Our Case Number: ABP-317121-23

Re: BusConnects Swords to City Centre Bus Corridor Scheme
Swords to Dublin City Centre

Ref: Projects/Collinstown, Swords Road – Bus Connects

**Traffic Consultant Review of NTA Bus Connects Project Proposals, Swords to City Centre and Impact on:
Plot List: 1096(1).2a – Brendan Collins**

Programme Title BUSCONNECTS DUBLIN CORE BUS CORRIDORS INFRASTRUCTURE WORKS			
Drawing Title SWORDS TO CITY CENTRE CORE BUS CORRIDOR SCHEME TRAFFIC SIGNS AND ROAD MARKINGS			
Drawing File Name	Sheet Number	Status	Rev
BCIDB-JAC-TSM_GA-0002_XX_00-DR-CR-0013	13 of 37	A	M01

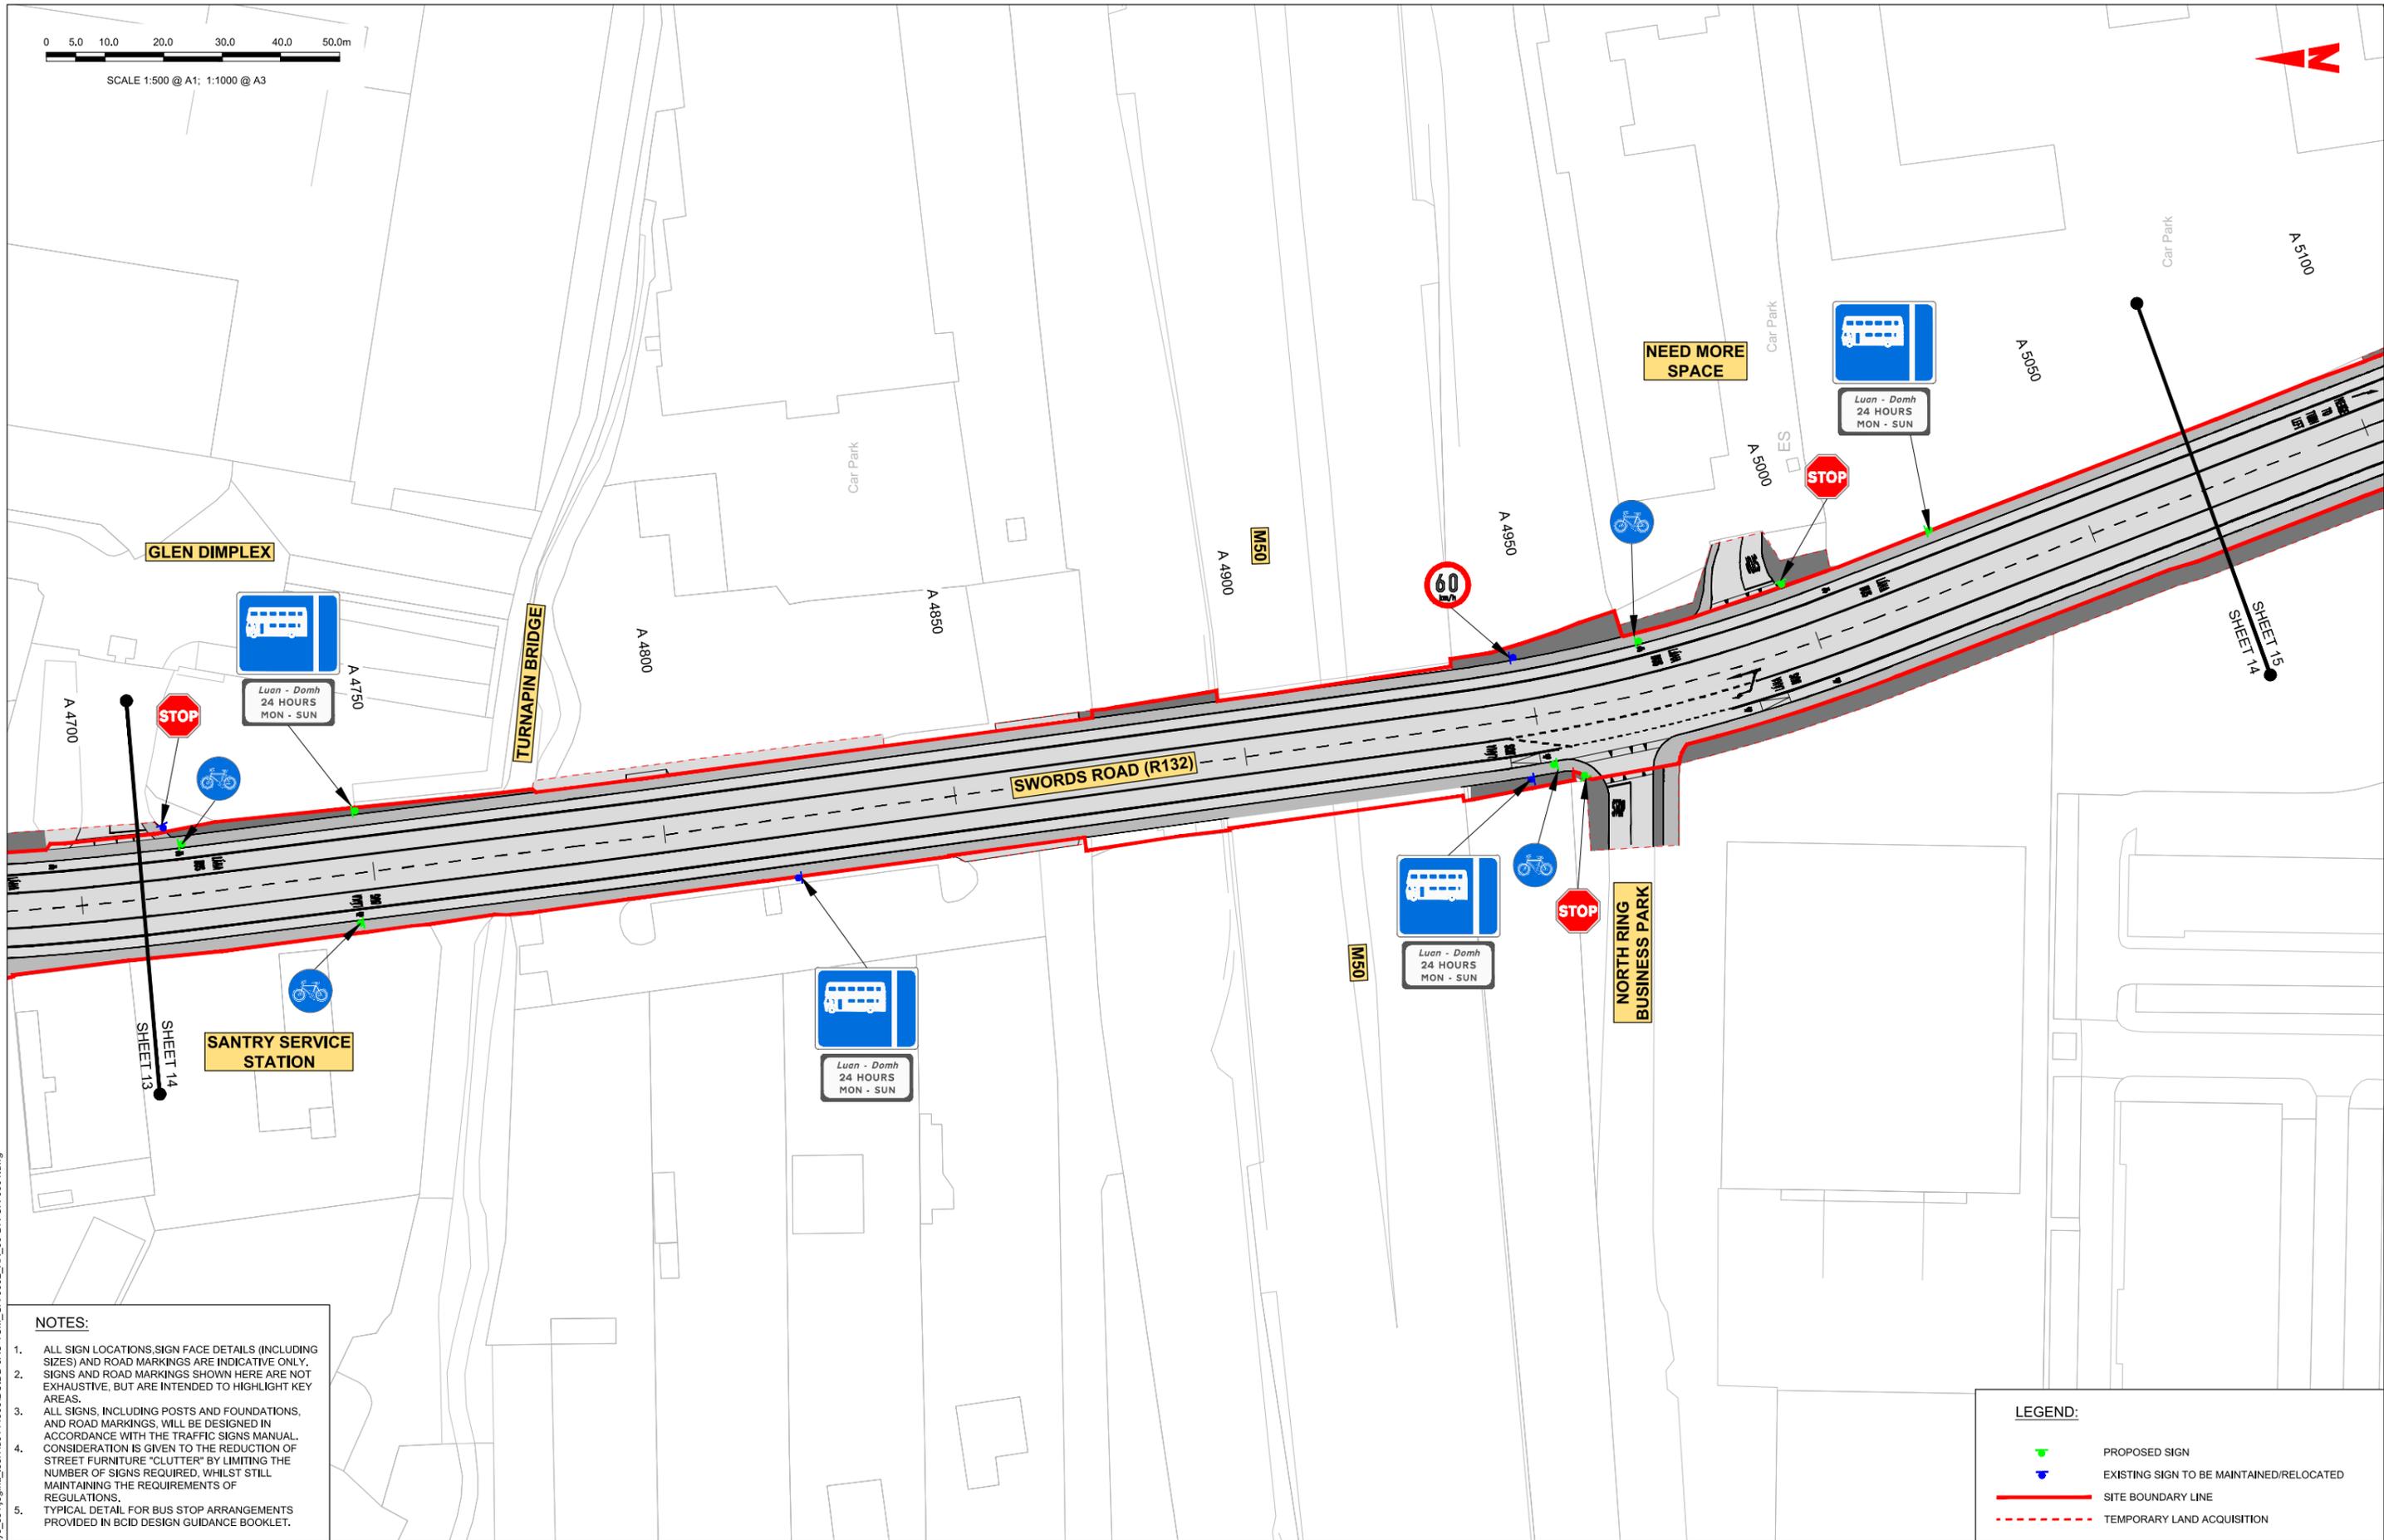
What is illustrated on the drawing Sheet 13 of 37 is a revised access layout with reduced access width formed by new kerblines and landscaping zones extending from the Swords Road junction to the setback gate.

Currently there are two exiting lanes and a wide entrance lane area to accommodate large HGVs, buses and coaches entering and exiting the access. There is also a dividing barrier between the inbound and outbound lanes to prevent vehicles entering the access from Swords Road and using it to u-turn in the bellmouth area, and some flexipost bollards and associated signage to advise that there is to be no parking in the area between the Swords Road and the setback access gate.

The scheme drawing Sheet 13 of 37 also shows a proposed entry treatment ramp across the reduced width access, with the public footpath crossing point stepped inwards onto the flat zone area of the entry treatment ramp (so that it would be partially behind the site boundary line), and the stopline/Stop road marking text has been located to the rear of the inner toe of the entry treatment ramp.

It is noted that the narrow form of entry treatment ramp proposed on Sheet 13 of 37 would result in HGVs and buses bumping up and down over the ramp, which could have impacts on the drivers and their vehicles but would also result in increased noise impacts on the adjoining residential dwellings.

It is disingenuous for the NTA Bus Connects promoters to claim this is a temporary acquisition when they are proposing wholesale changes to the lands in question and are not reinstating the existing arrangements before returning the lands to the permanent owners.

SRC submit that the current Bus Connects proposals on General Arrangement Sheet 13 of 37 are unacceptable as these will have a significant and detrimental impact on the Business Park and the tenant companies by limiting operational and servicing access, with a significant impact on customer and staff safety, inoperable for the existing businesses during the works and impacting on the current arrangements when the proposed works are completed.
